25495/A3/LT/ck/ds

19th February 2016

RESERVED MATTERS PLANNING APPLICATION FOR THE LAYOUT, SCALE, APPEARANCE, LANDSCAPING AND INTERNAL ACCESS ARRANGEMENTS IN CONNECTION WITH THE ERECTION OF 141 DWELLINGS, AREAS OF OPEN SPACE AND ASSOCIATED INFRASTRUCTURE AND ANCILLARY WORKS PURSUANT TO OUTLINE PLANNING APPROVAL 2014/0452

CLIENT	HARWORTH ESTATES				
PROJECT	NORTH GAWBER				
TITLE	SUMMARY OF MINE ENTRIES (HARRON HOMES)				
JOB No.:	322014		DRAWING FILE:	322014-L08 00 D001A	
BY:	DATE:	CONTRACT NO.	REV:		
HD	16.02.16		FIGURE 1		A

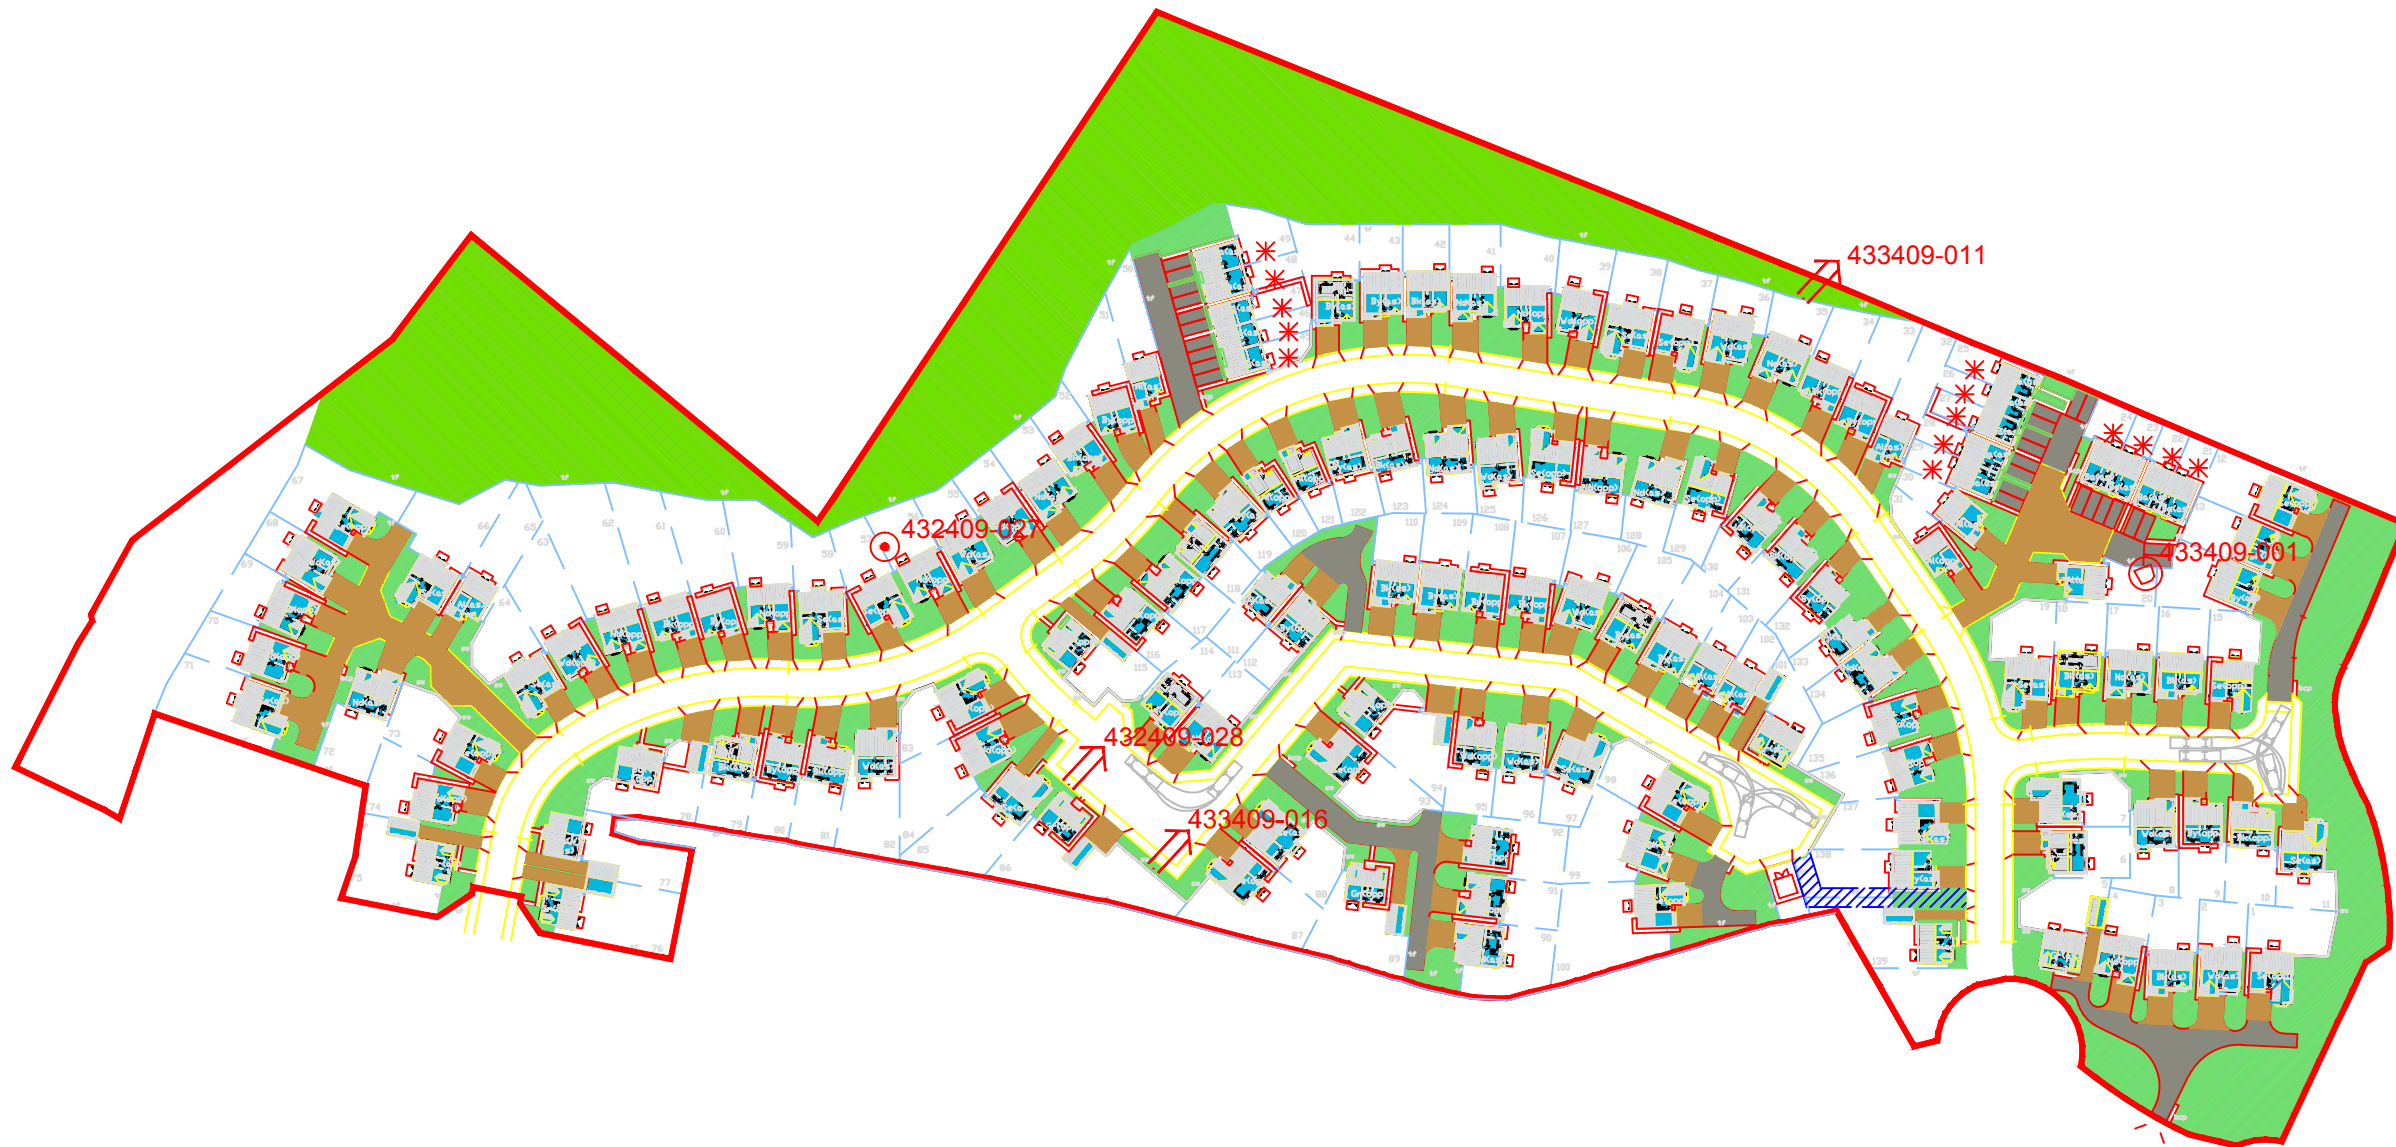
The responses from both SYMAS and the Coal Authority have requested further information in relation to the mine shafts on the Harron Homes parcel of the site.

RSK (on behalf of Harworth Estates) have undertaken significant investigation works and full details of these investigations, including appropriate mitigation measures, have now been formally submitted to the Coal Authority. It is our understanding that discussions between RSK and the Coal Authority are still ongoing but the exact location of the mine shafts and appropriate standoff zones have been agreed and these are now detailed on the enclosed site plan.

It is considered that this should now address the concerns raised by both SYMAS and the Coal Authority.
